SSD8606 - RESPONSE TO SUBMISSIONS - LOT 23 & 24 HOLLINSWORTH ROAD, MARSDEN PARK

This Response to Submissions (RtS) provides responses to the agency and community submissions received during the public exhibition of the Environmental Impact Statement (EIS) for a warehousing and distribution estate at Lot 23 and 24, Hollinsworth Road, Marsden Park (SSD 8606).

2 21 Dec - 12pm
1 : 2000

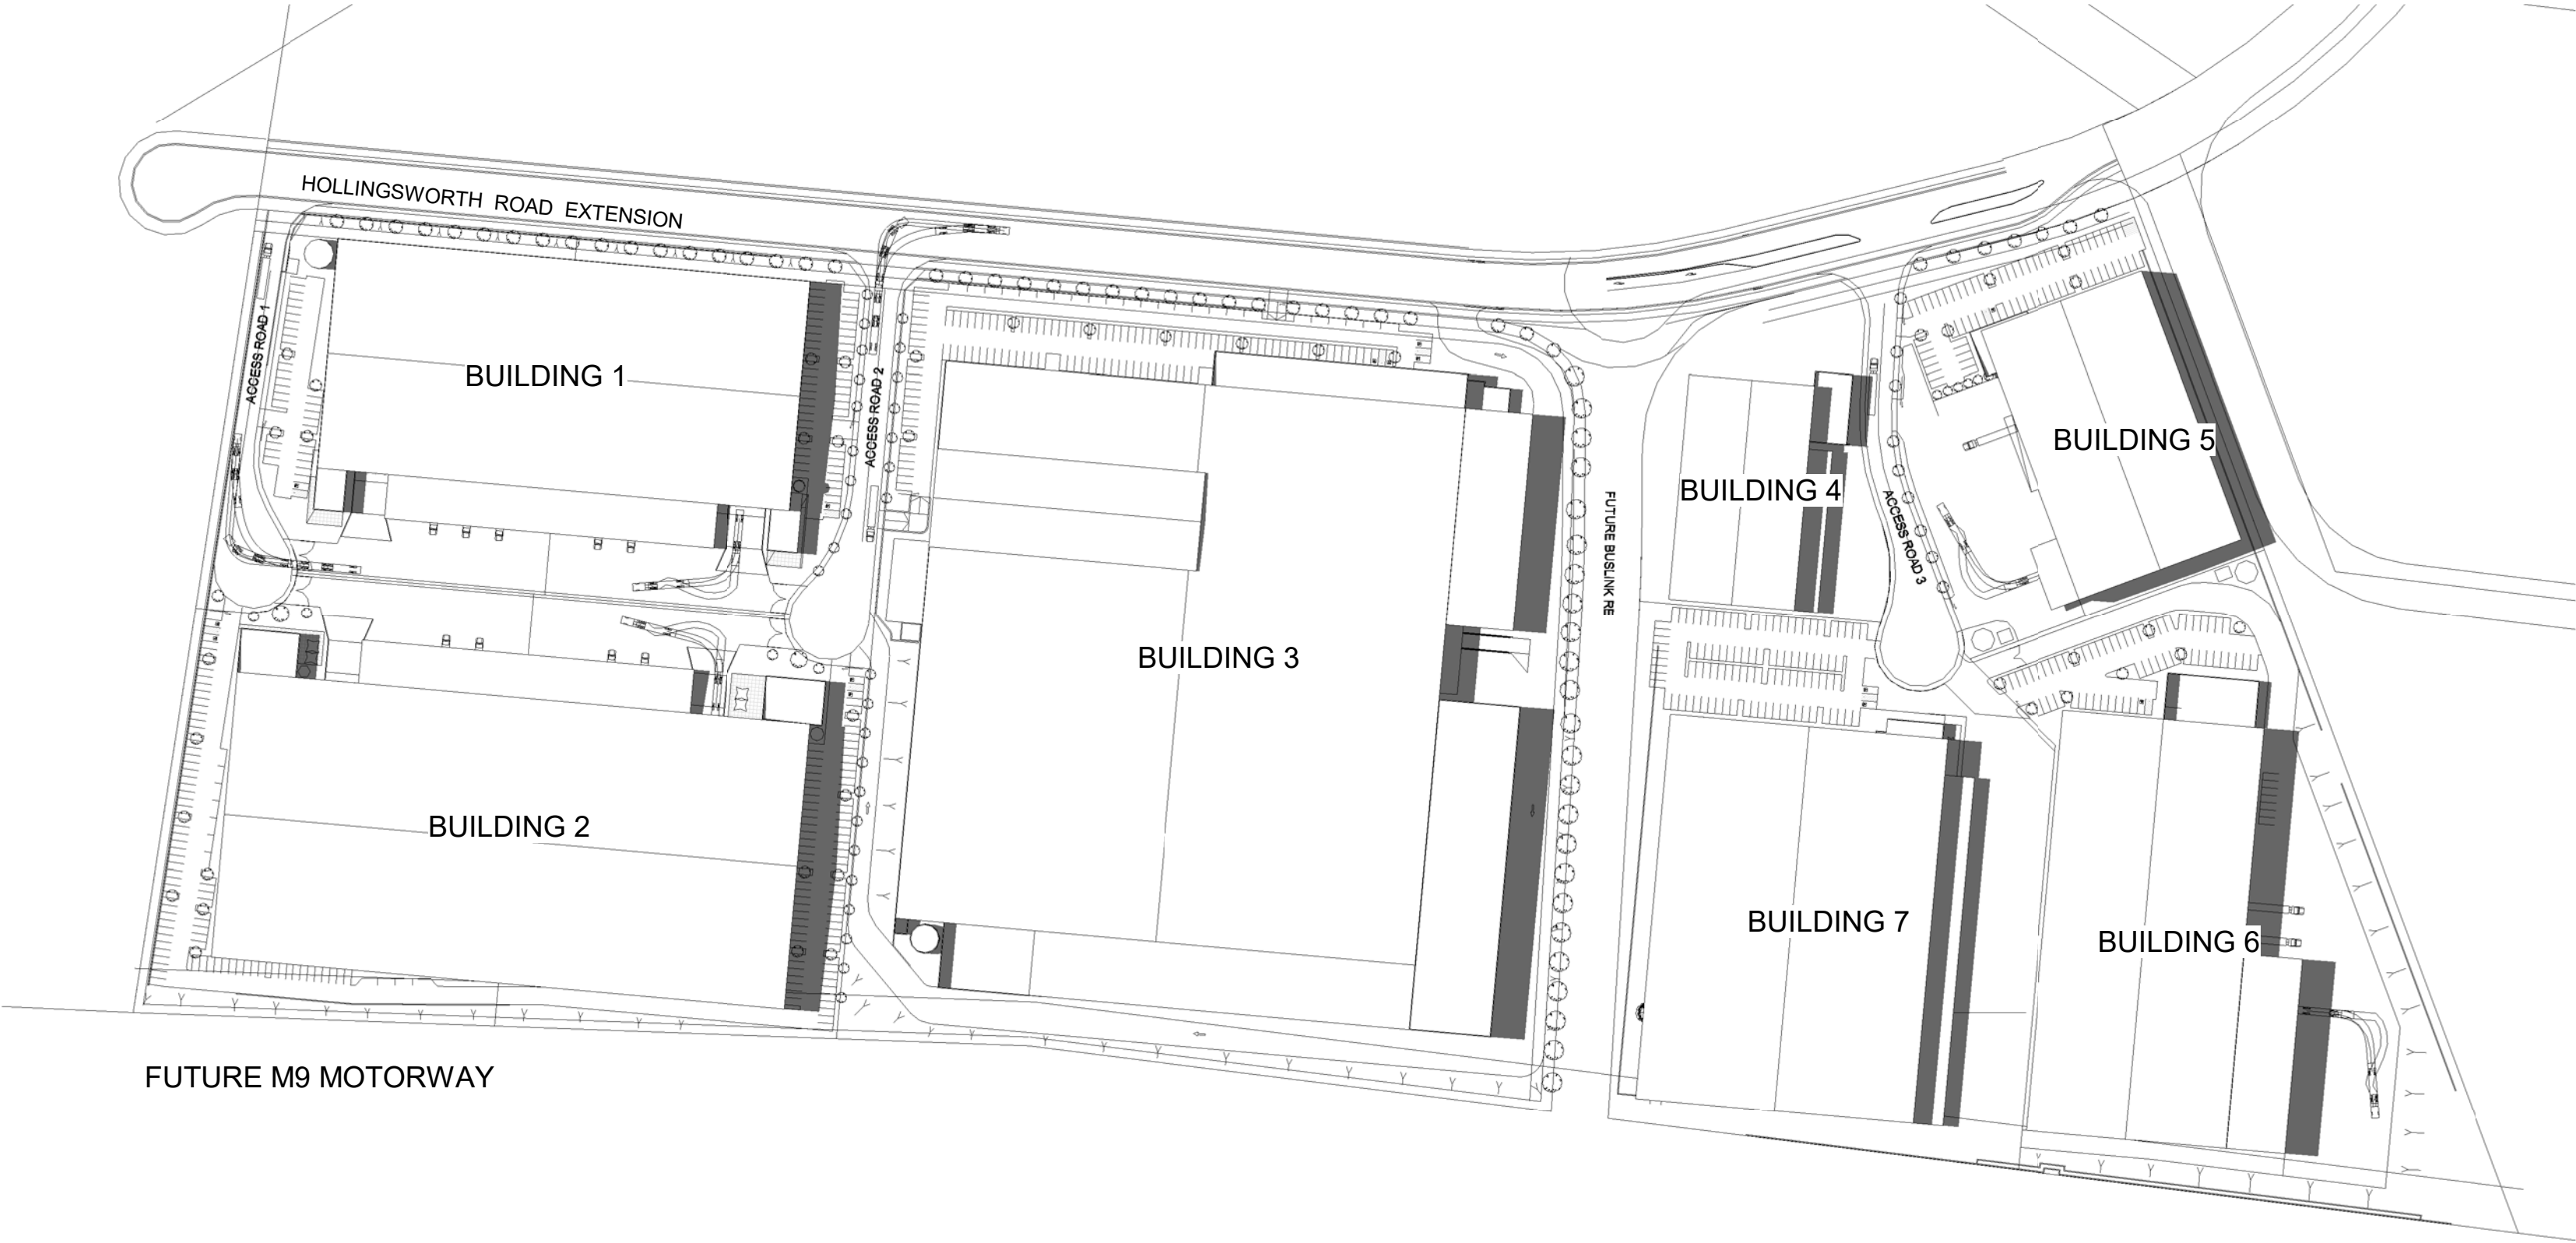
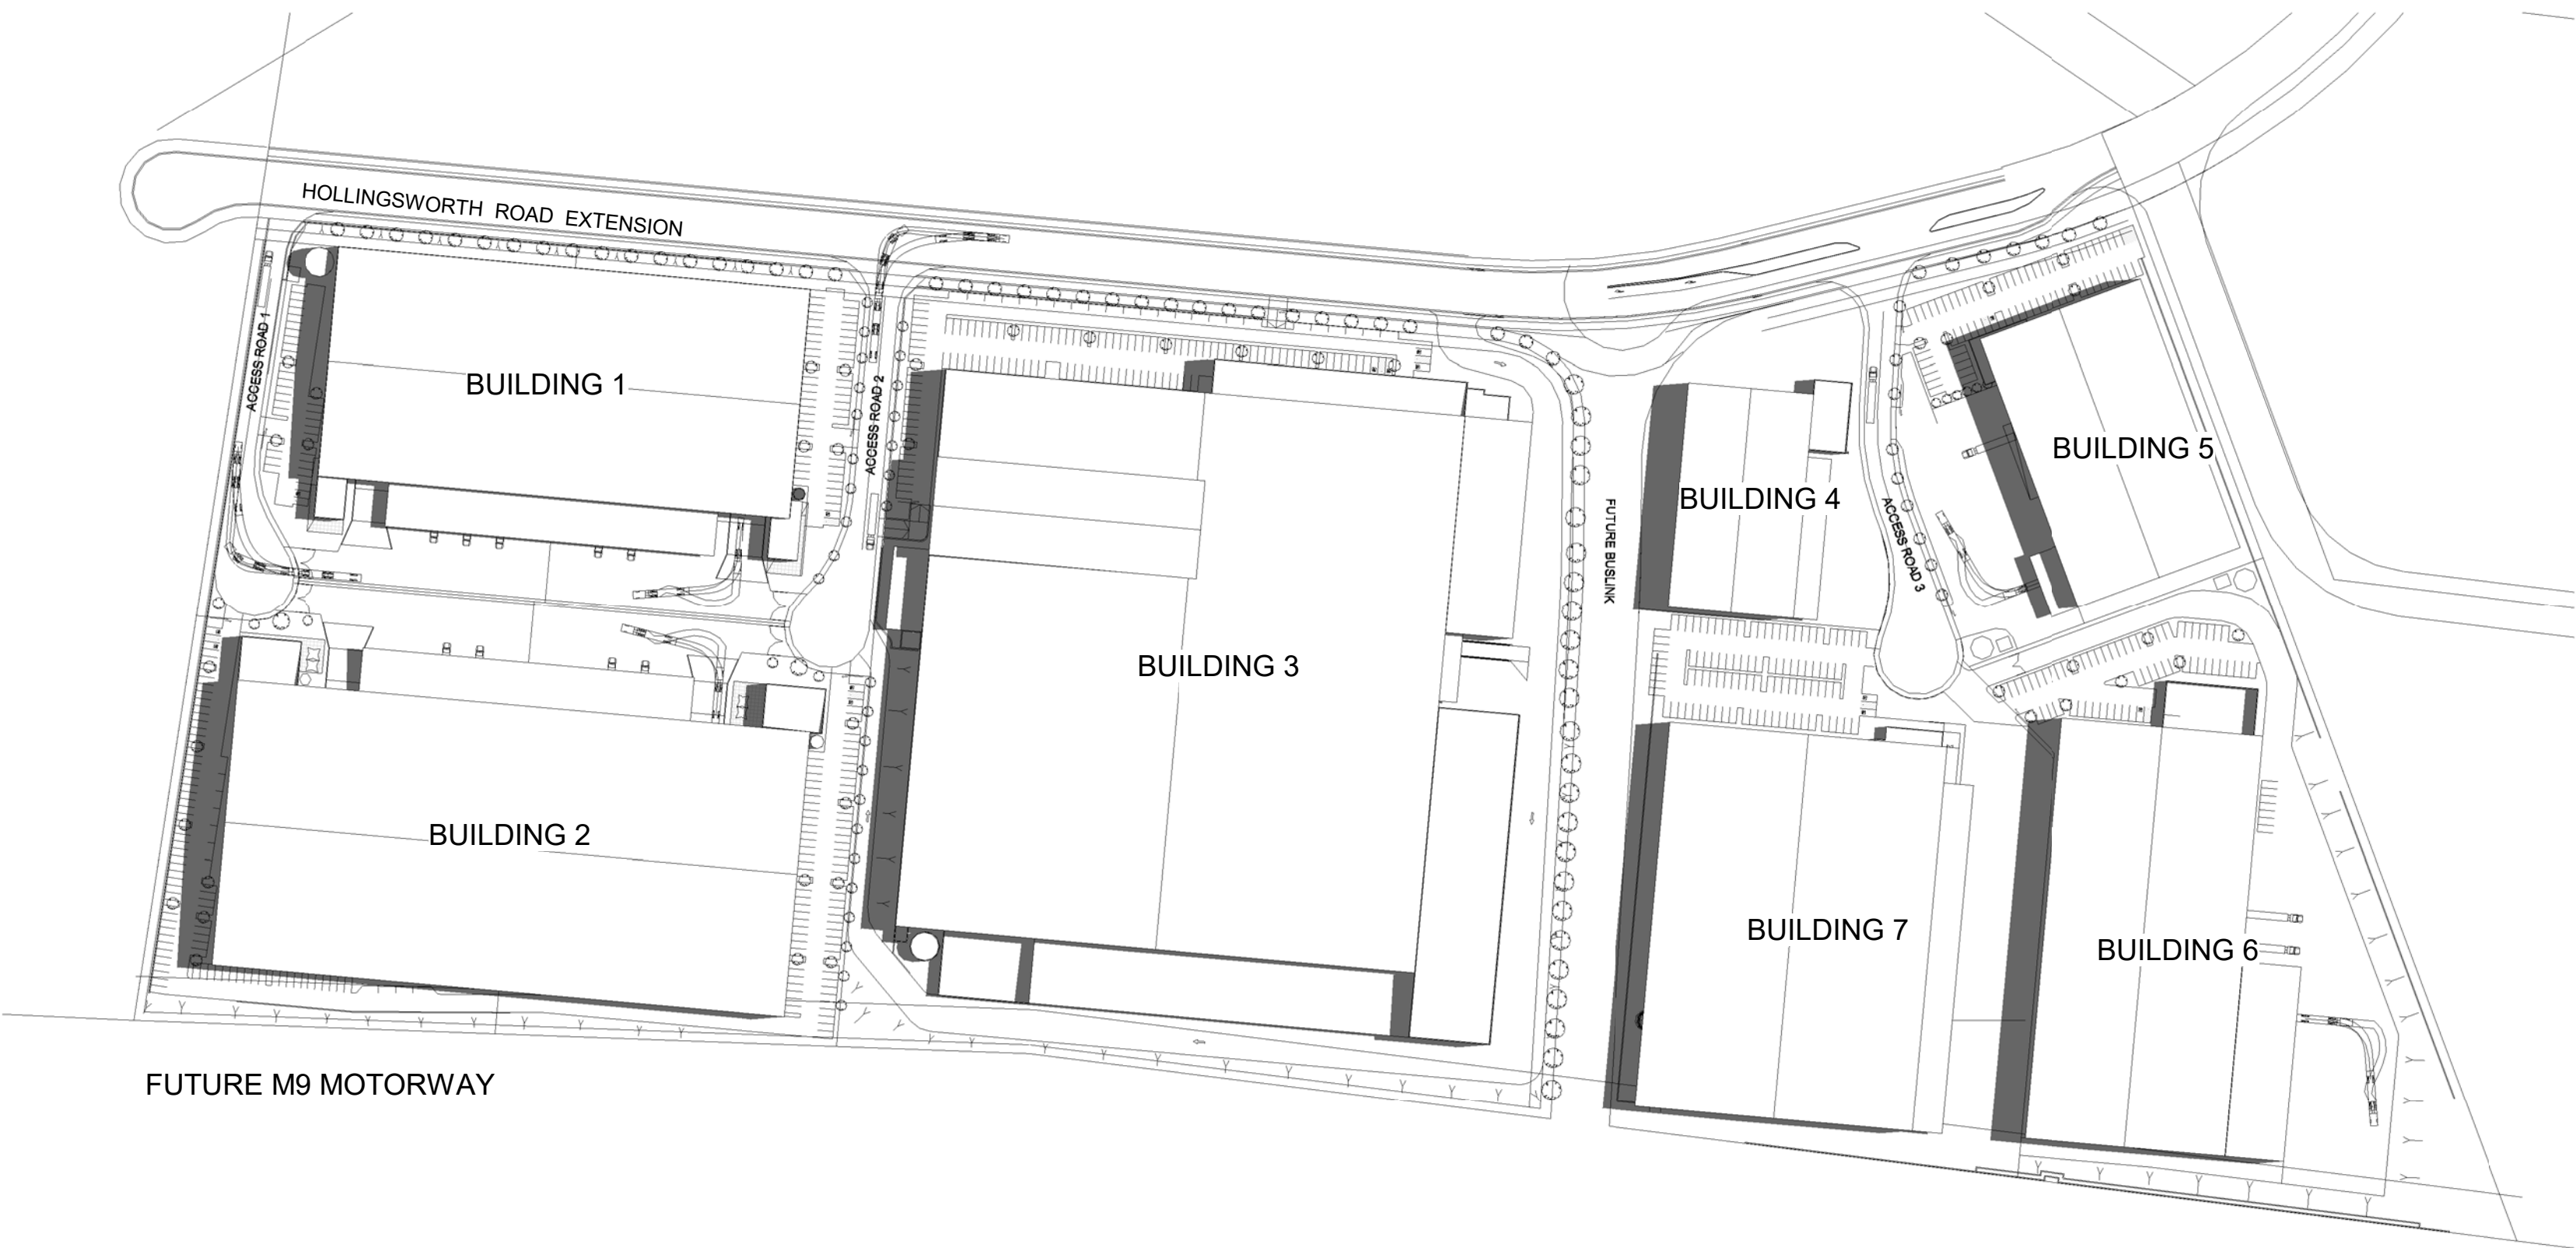
| Item Raised | Proponent's Response |
|-------------------------------------------------------------------------------------------------------------------------------------------------------------------------------------------------------------------|---------------------------------------------------------------------------------------------------------------------------------------------------------------------------------------------------------------------------------------------------------------------------------------------------------------------------------------------------------------------------------------------------------------|
| A shadow diagram should be provided. | Shadow diagrams have been prepared to show shadows at 9am, 12pm and 3pm on 21 December and 21 June. |

| Item Raised | Proponent's Response |
|--------------------------------------------------------------------------------------------------------------------------------------------------------------------------------------------------------------------------------------------------|--------------------------------------------------------------------------------------------------------------------------------------------------------------------------------------------------------------------------------------------------------------|
| | <p>No detrimental shadow impact is generated by the proposal, given the separation distances between the site and the public domain / residential receivers.</p> <p>Refer to drawings LG-MAR-S1 and LG-MAR-S2.</p> |
